OUT21/14060

**Yiribana Logistics Estate (SSD-10272349) –
Environmental Impact Statement (EIS)**

Detailed advice to DPIE Planning & Assessment regarding the Yiribana Logistics Estate (SSD-10272349) – Environmental Impact Statement

E2 CORRIDOR ALIGNMENT PLAN
SCALE 1:500

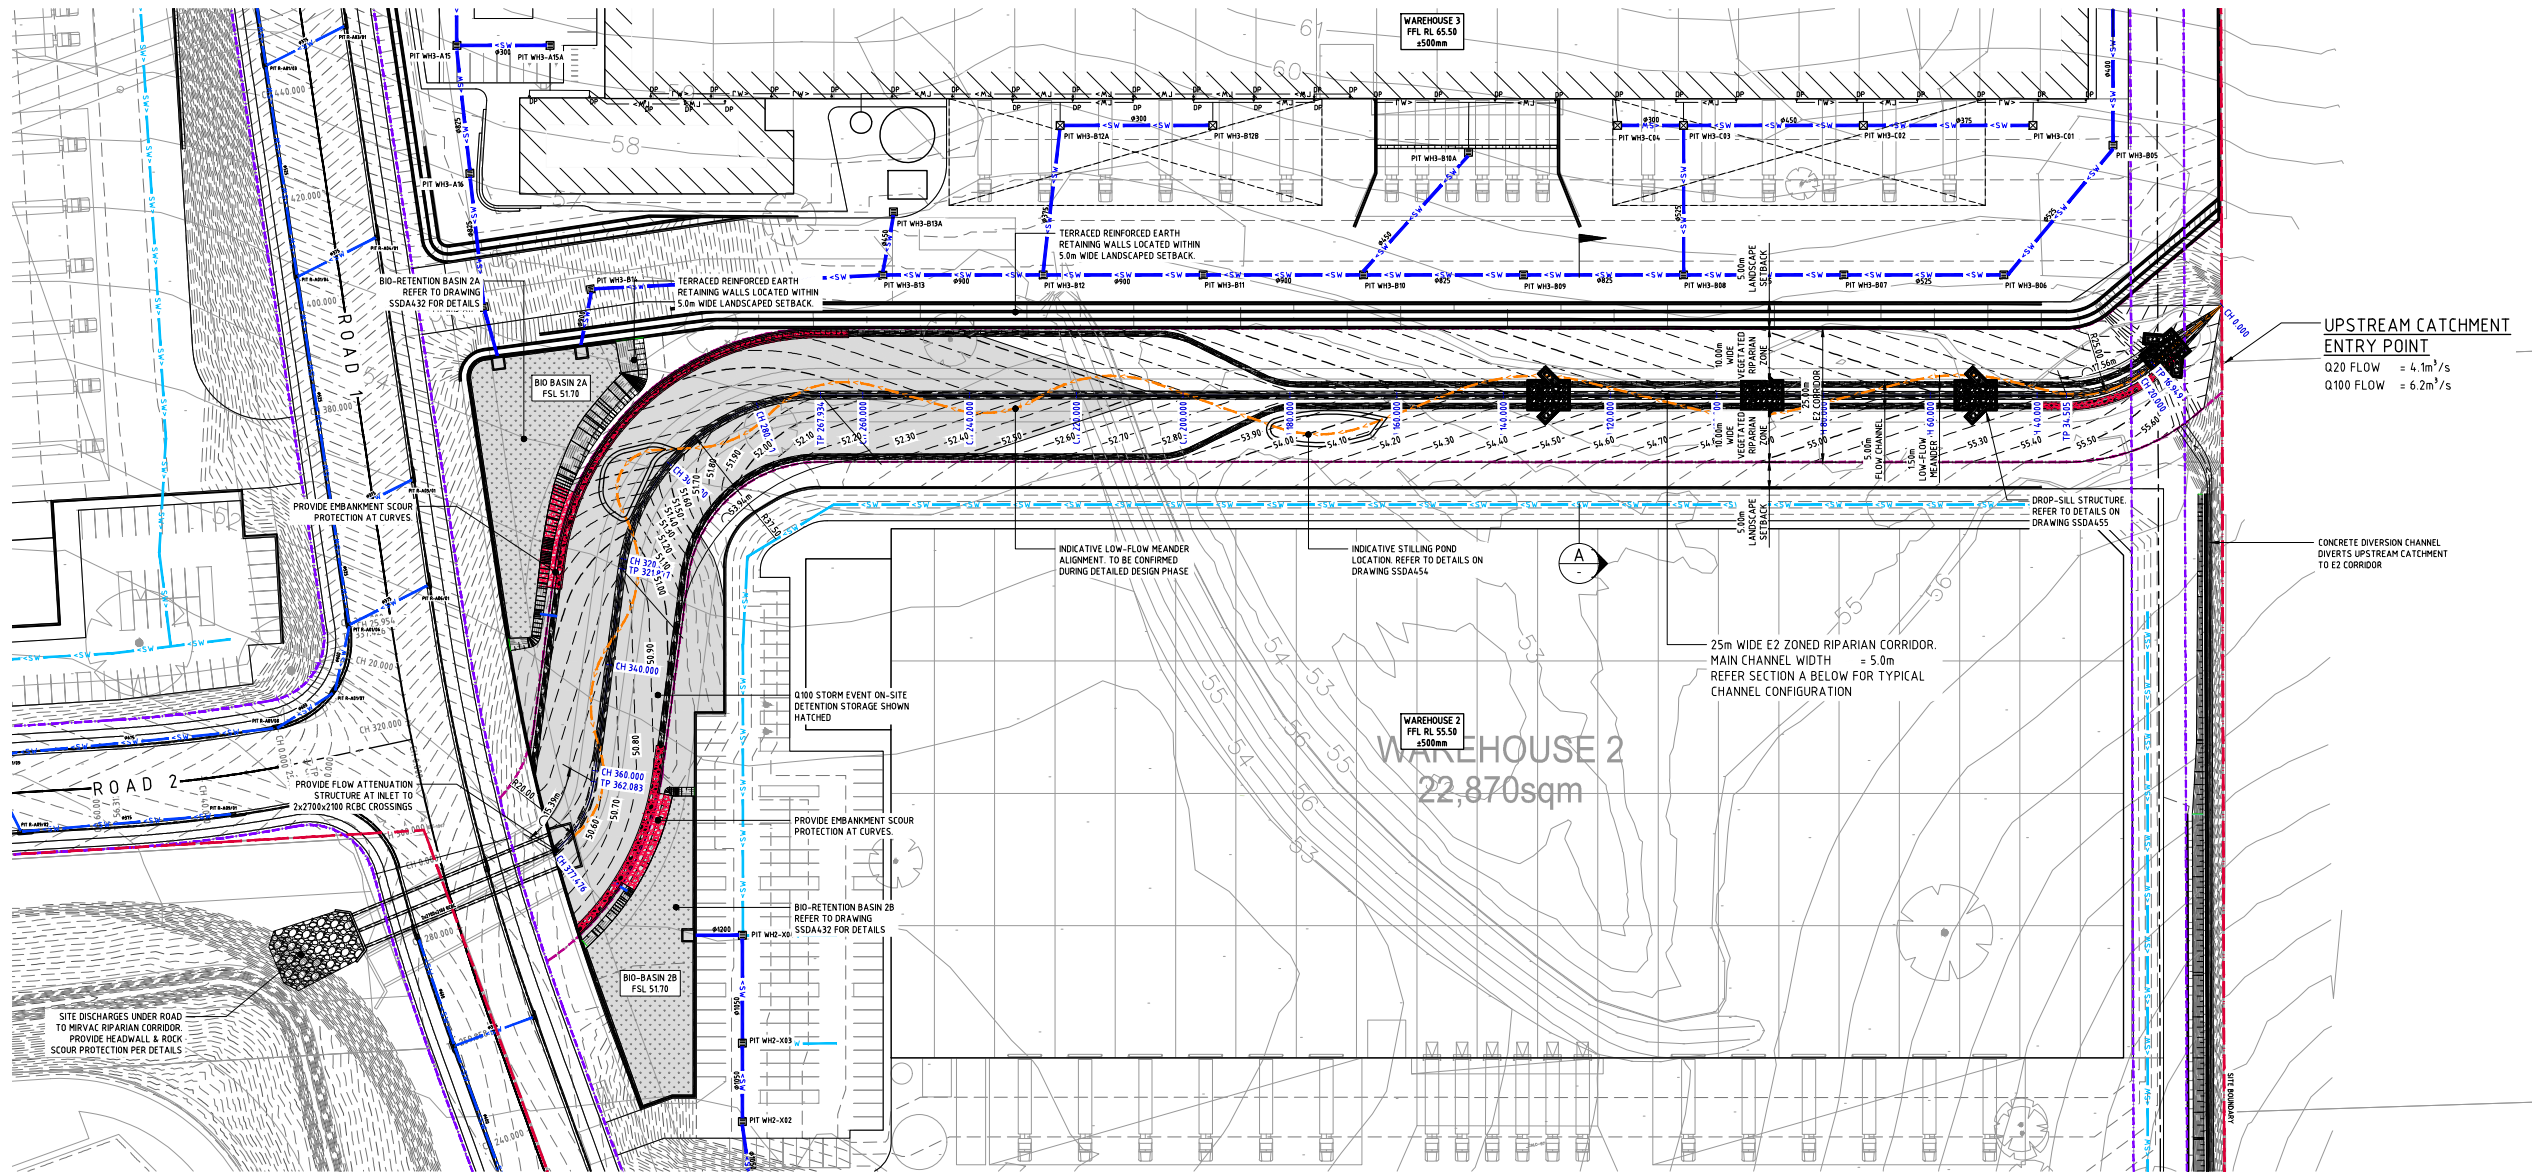
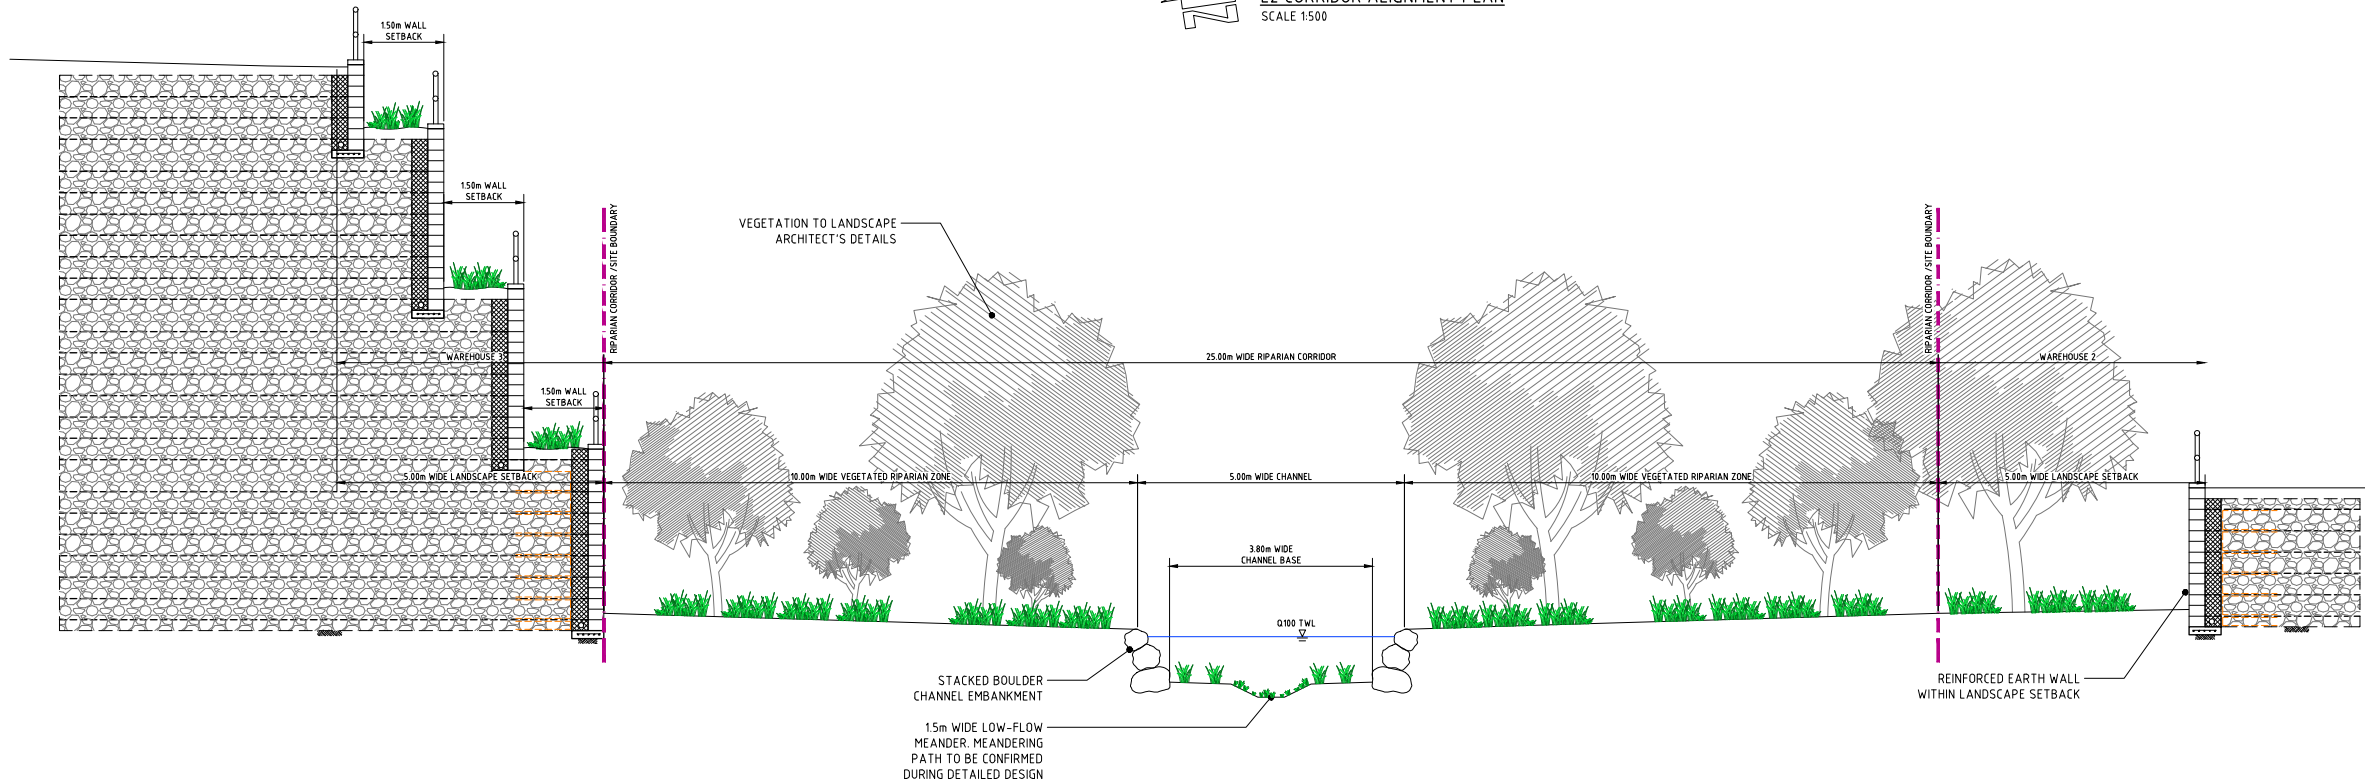
either side, and an outer Vegetated Landscape Zone of approximately 5m width on either side.’ The EIS Watercourse Riparian Zones Figure (Figure 3 below), refers to the outer 5m Vegetated Landscape Zone as the Landscape Set-back, and this has not been included in the riparian calculations according to the Figure 3. Therefore, it is unclear whether the Vegetated Landscape Zones are part of the riparian corridor or not. Furthermore, from the plans provided in Appendix K (Civil Plans) the Vegetated Landscape Zones are only present in some sections along the watercourse or on one side (as shown in Figure 3 below).

NRAR believes that the proponent actually proposes a total riparian area of 20m which is composed of two 10m wide inner Vegetated Riparian Zones either side of the waterway. Should the Landscape Zones be included in the calculations, it is still less than the 40m recommended corridor width for 2nd order streams. We recommend that a 40 metre riparian corridor be required consistent with the Guidelines for Controlled Activities on Waterfront Land (NRAR 2018).

NRAR notes that the low-flow meander appears to be currently mapped (significantly) outside of the proposed 5-metre channel width on the upstream (eastern) side.

The proponent should provide further details on the low-flow path (as shown in Figure 1 below) regarding the associated channel containment infrastructure. NRAR notes that the channel design appears to change over the course of the site (as seen in Figure 1) from east to west (right to left), and that Figure 2 (below) indicates that this flow path will be contained on the upstream side within a 5-meter-wide channel (contained by rock embankments). NRAR acknowledges the low-flow meander alignment is indicative (and to be confirmed during the detailed design phase), but has concerns regarding the significant distance difference between the low-flow path meanders and the proposed channel path, especially in the eastern/upstream section where the channel is confined to 5 metres wide. NRAR also suggests that Drawing C013874.06-SSDA420 (E2 Corridor General Arrangement Plan from Appendix K – Civil Drawings) should clearly indicate where the location of the cross-sections are mapped.

NRAR notes that in a meeting held with Urbis on 3/8/20, it was agreed that the watercourse within the site was to be re-aligned and that re-alignment should not include any 90 degree sharp meanders, as well as mimic natural stream design to minimise impacts to remanent vegetation areas upstream of the site.

2.1 The proponent should maintain a 40 metre riparian corridor in accordance with the *Guidelines for Controlled Activities on Waterfront Land (NRAR 2018)*.
